**Consultation Response from KC,
Highways Development Management**
2020/92777 adj, 22, Gib Lane, Skelmanthorpe, Huddersfield, HD8 9BG
Erection of detached dwelling
**Date Responded:
05/10/2020**
**Responding Officer: Zack
Turner**
Responding Ref: 17-22-33

This application is on land adjacent to 22, Gib Lane, Skelmanthorpe, Huddersfield. The proposal is for the demolition of a detached garage and workshop for the erection of a detached dwelling.

Title: Proposed Site Plan

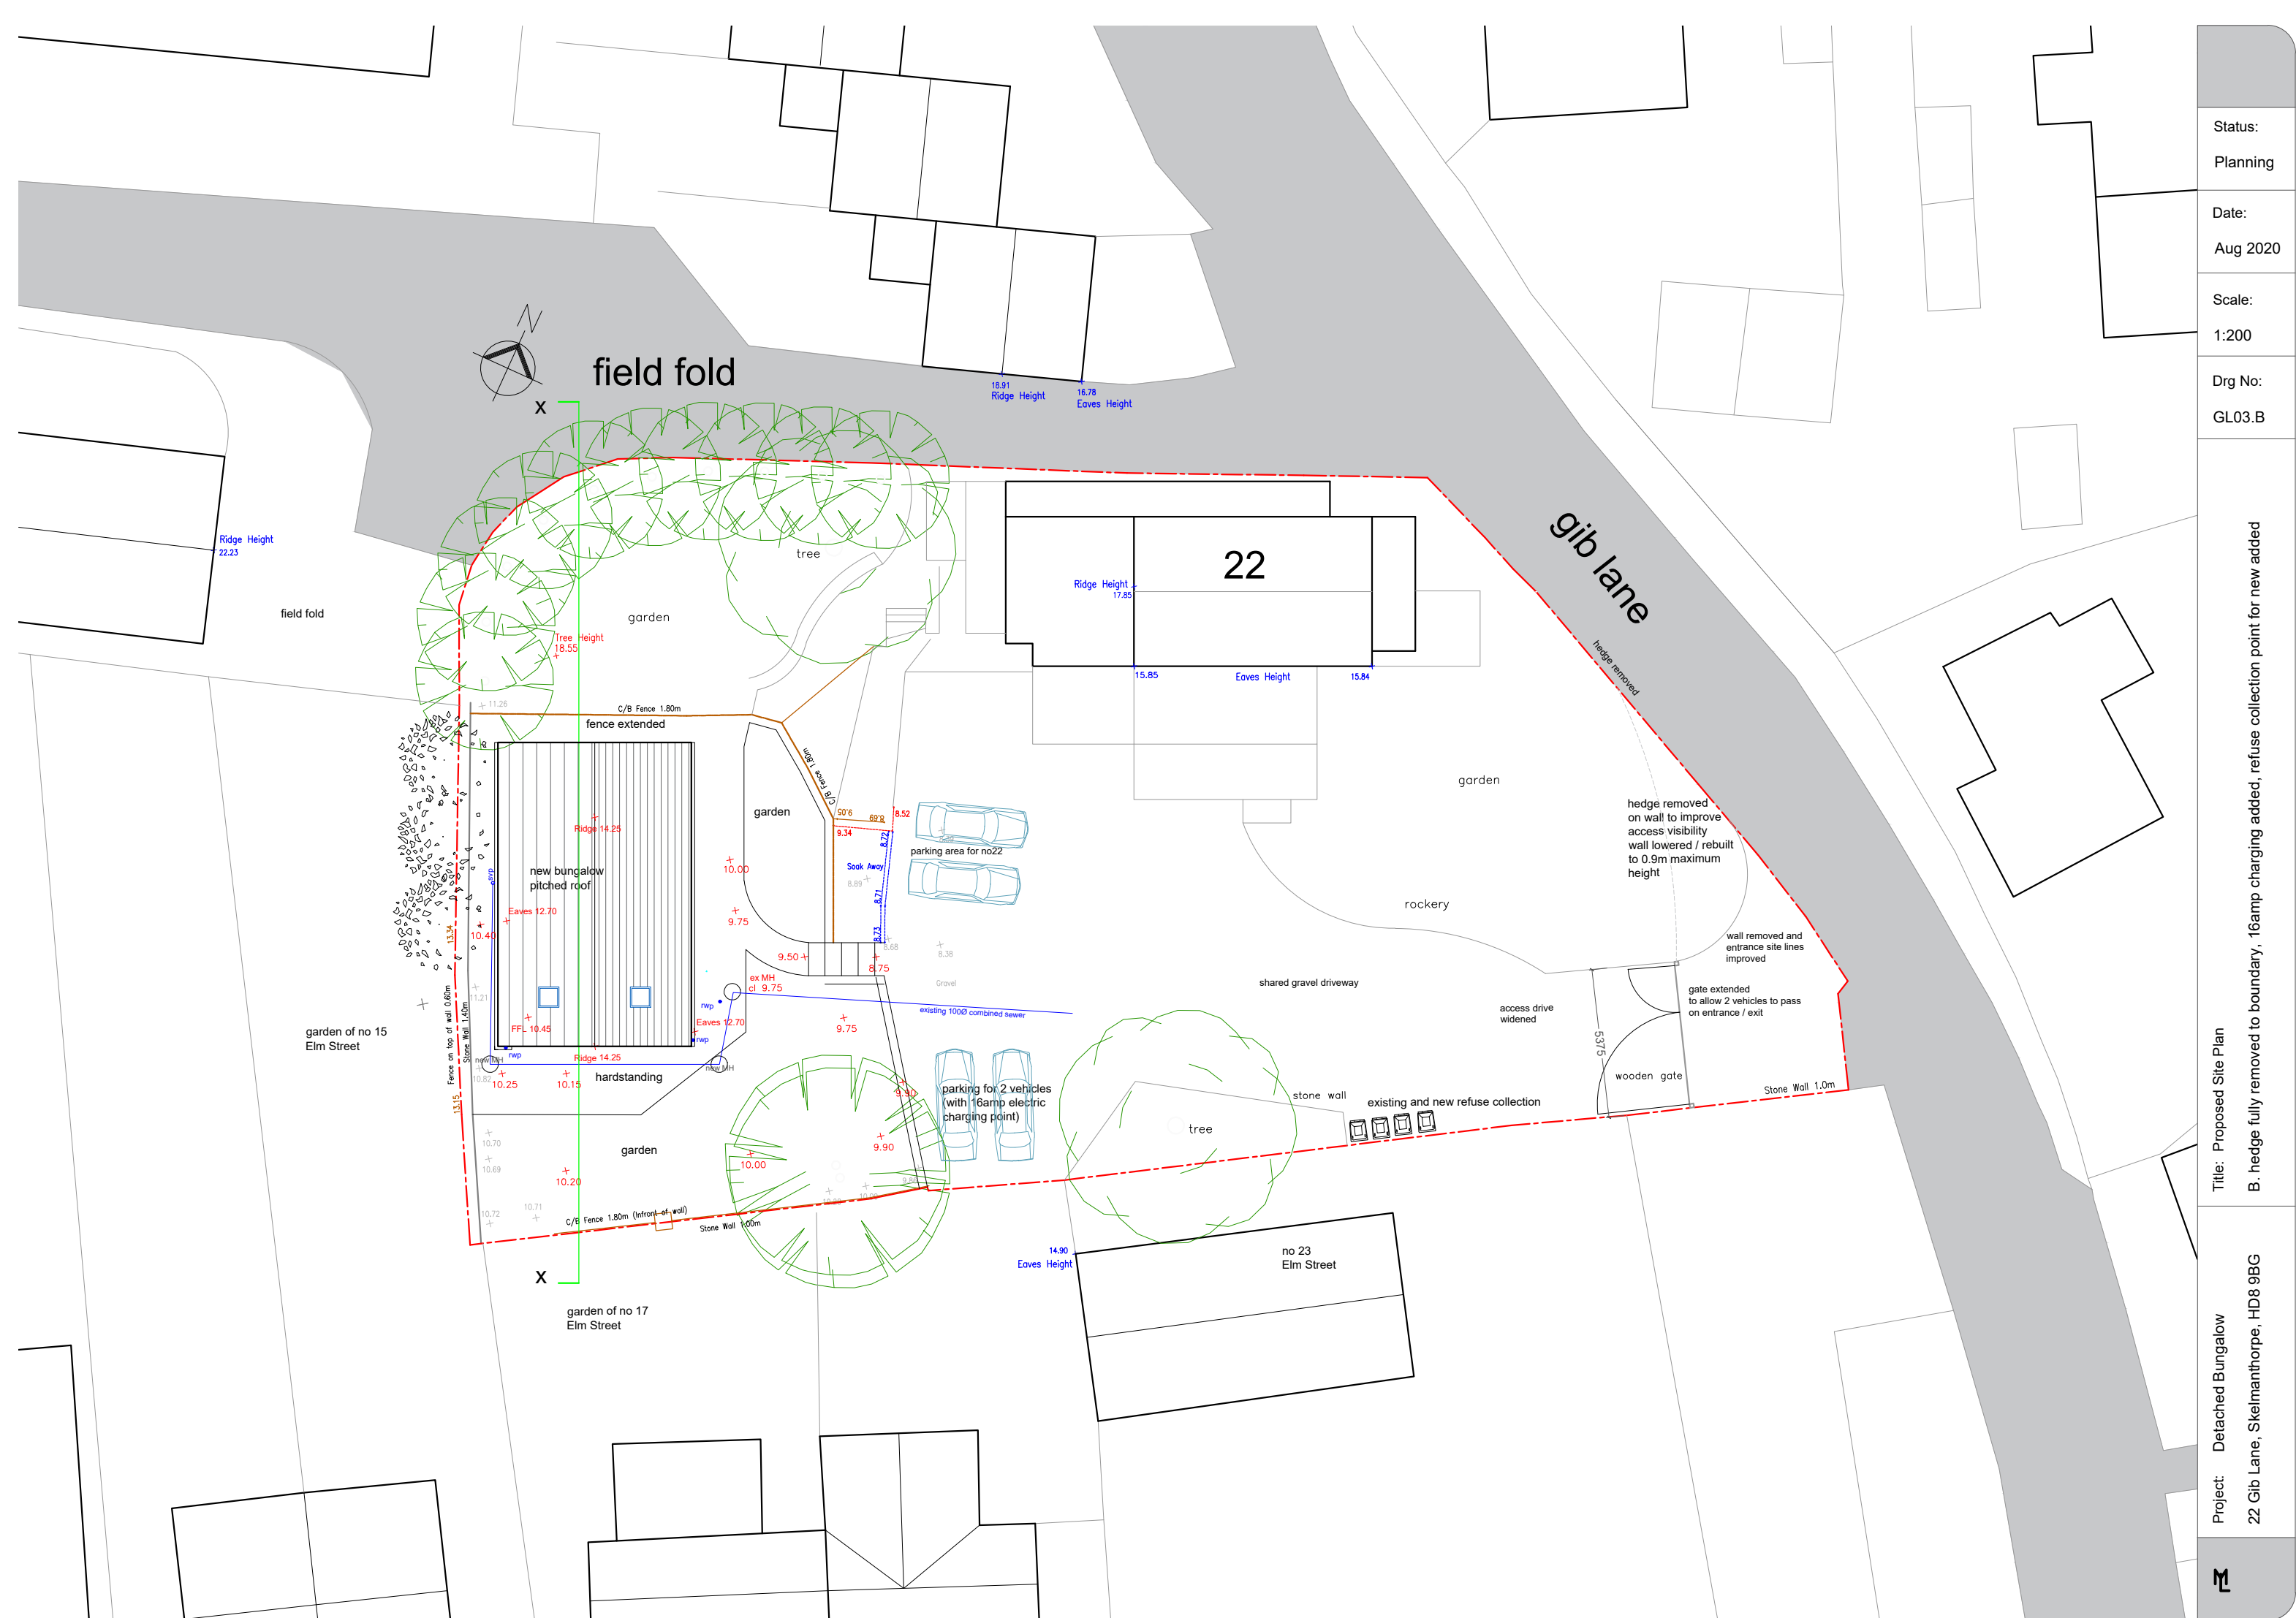
Waste storage is shown to be provided on the plan, utilising the existing waste storage point to number 22.

The driveway and gated access will be widened to allow to 2 vehicles to pass upon entry and exiting the site. The hedges adjacent to the site entrance will be removed to enhance visibility.

The new dwelling will be 2-3 bedrooms which will require a minimum of 2 parking spaces, and this is shown to be provided with an electric charging point. The removal of the detached garage for the existing dwelling will result in a loss of parking however ample off-street parking is retained as shown on the plan.

This application however provides insufficient detail.

The plans should be amended to show that the hedge and wall to the site frontage are to be reduced to a height of not exceeding 1.0m for the full frontage of the site.
